Our Case Number: ABP-321776-25

Re: BusConnects Galway: Dublin Road Development
R338 Dublin Road, Galway City.

Bus Connects Galway, Dublin Road Development, Bus Corridor Scheme

SUBMISSION

9.4 Design Year (2043) Traffic Noise

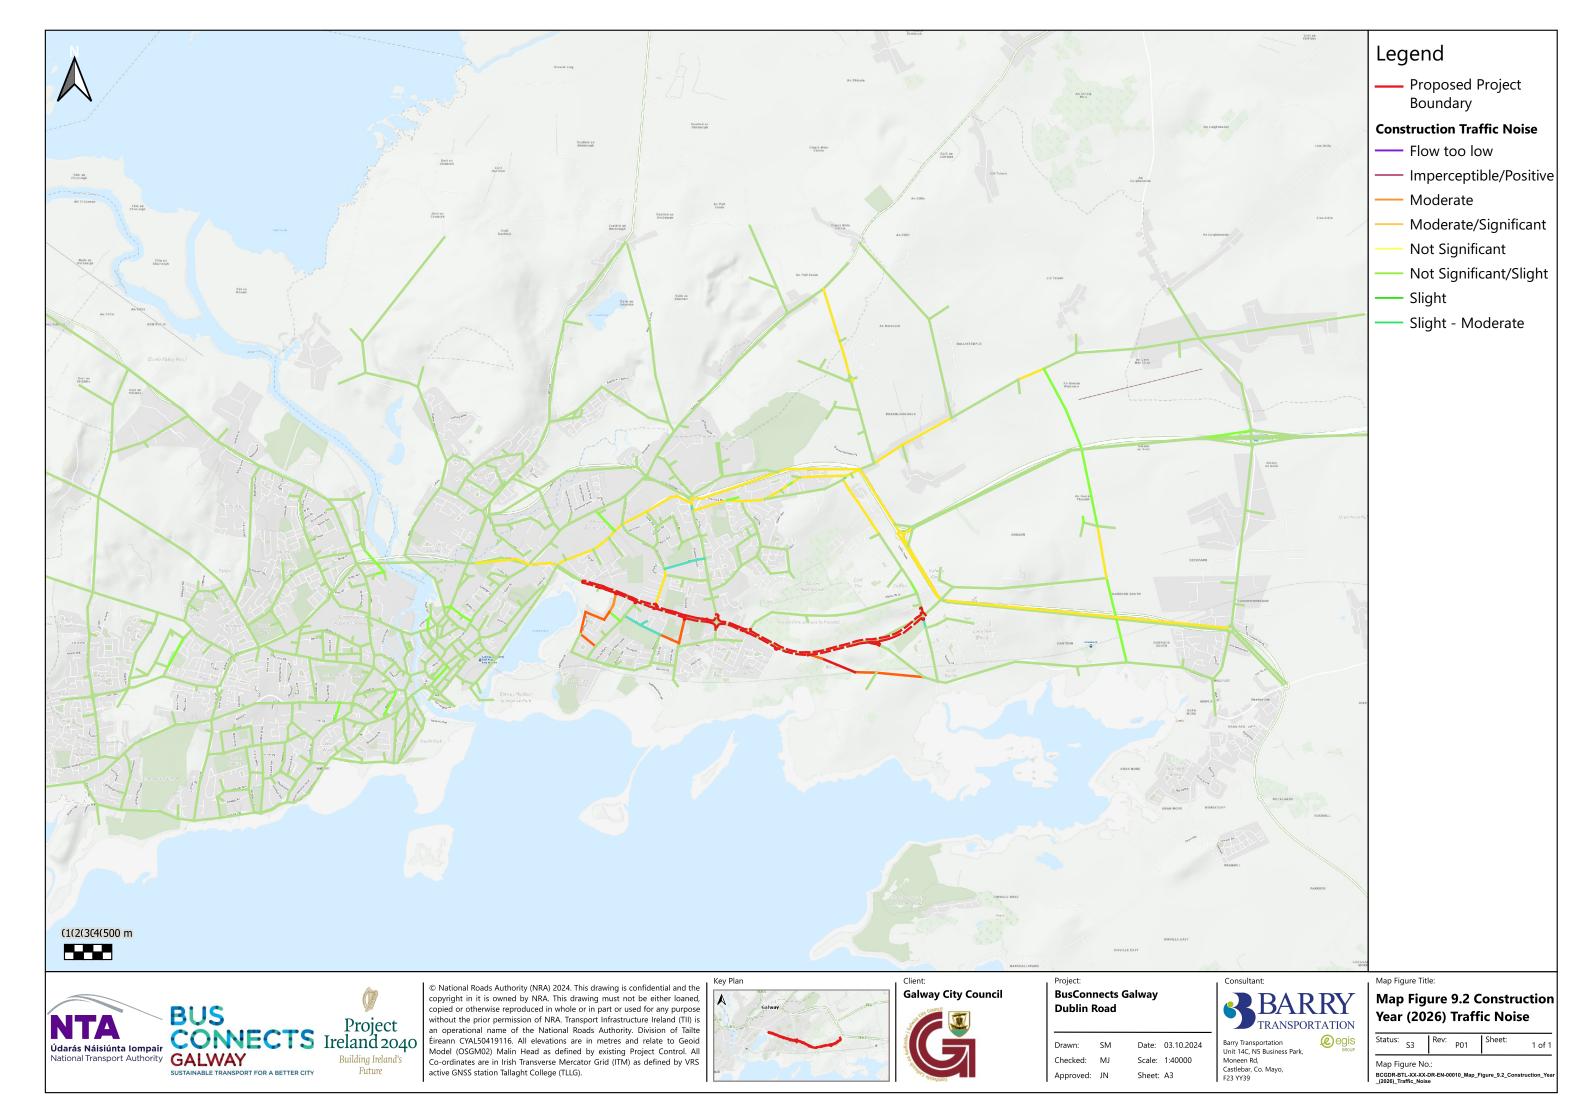
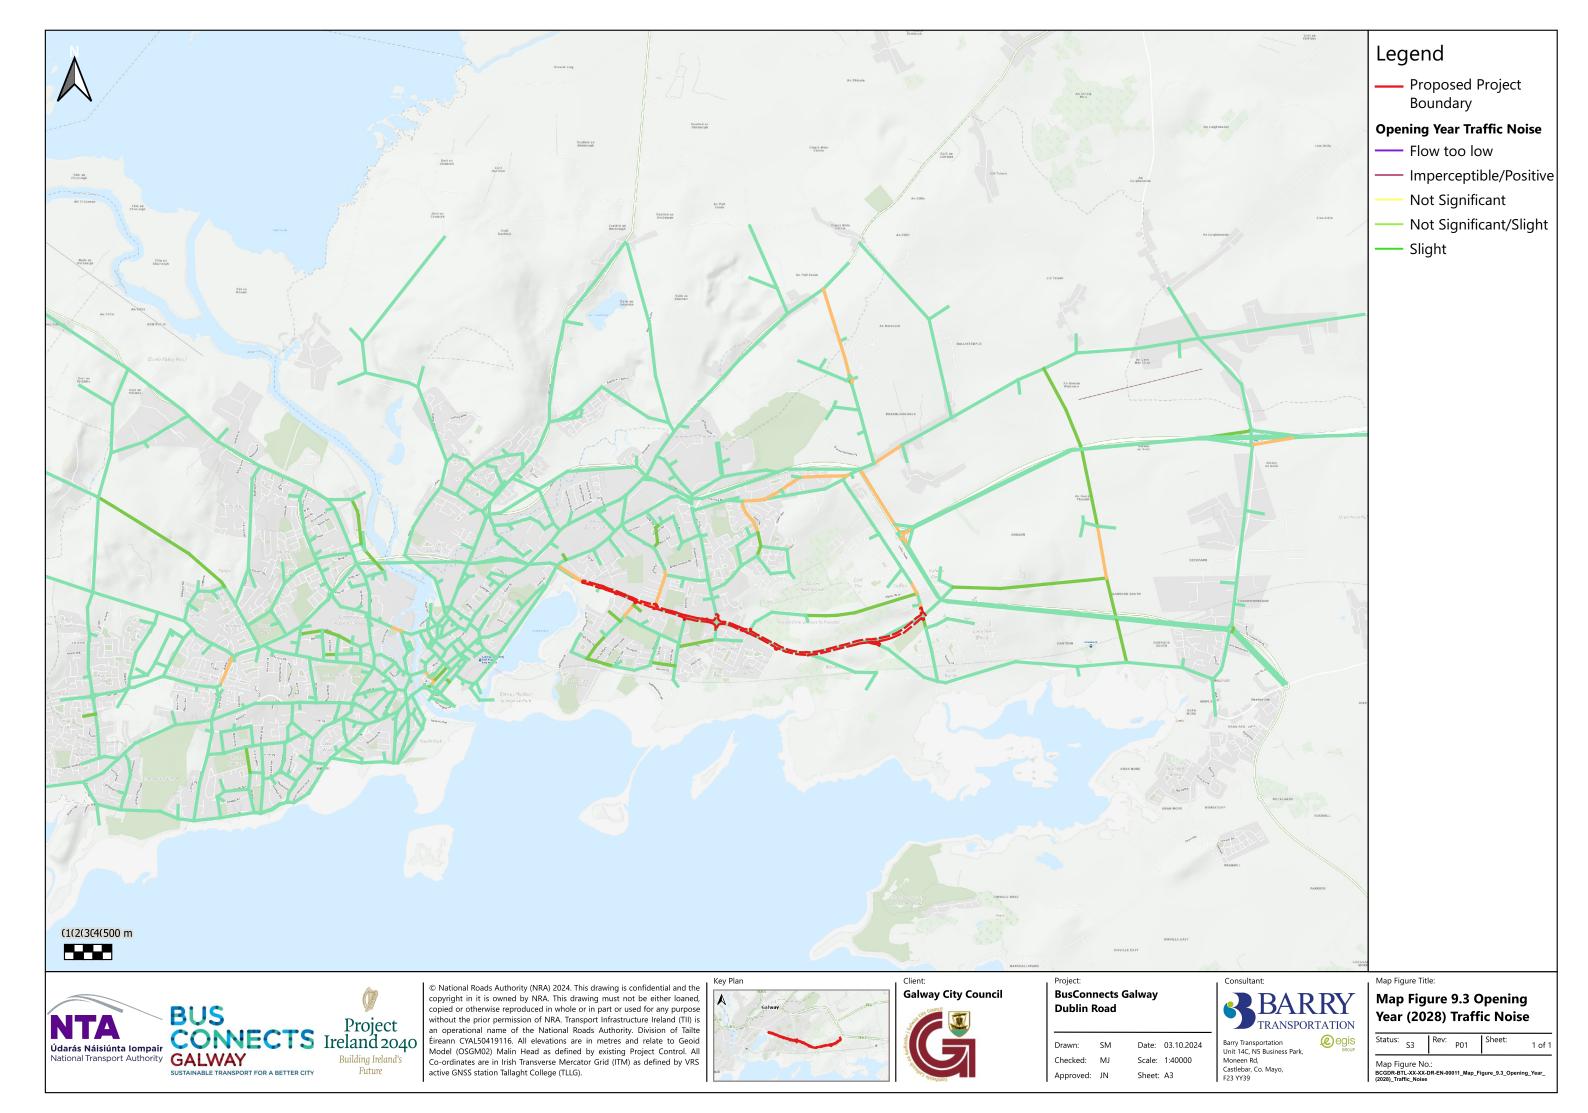
The Noise and Vibration report inaccurately states that our property is located 20 meters from the existing roadway. In reality, the correct distance is only 16 meters. More concerning, the report fails to properly account for the noise pollution that will result from the proposed plans. Our property will be situated just 9 meters from the new boundary wall. This oversight is significant, as it disregards the potential significant impacts on quality of life and health. It is crucial that this error, and many fundamental similar inaccuracies relating to distances and measurements are corrected and that the proper environmental assessments are conducted before the scheme proceeds further in the planning process. The current assessment is not considered a satisfactory basis upon which to determine the significant impacts of the development with a suitable level of scientific surety. The results of calculations and the findings of the report cannot be relied upon by An Bord Pleanála.
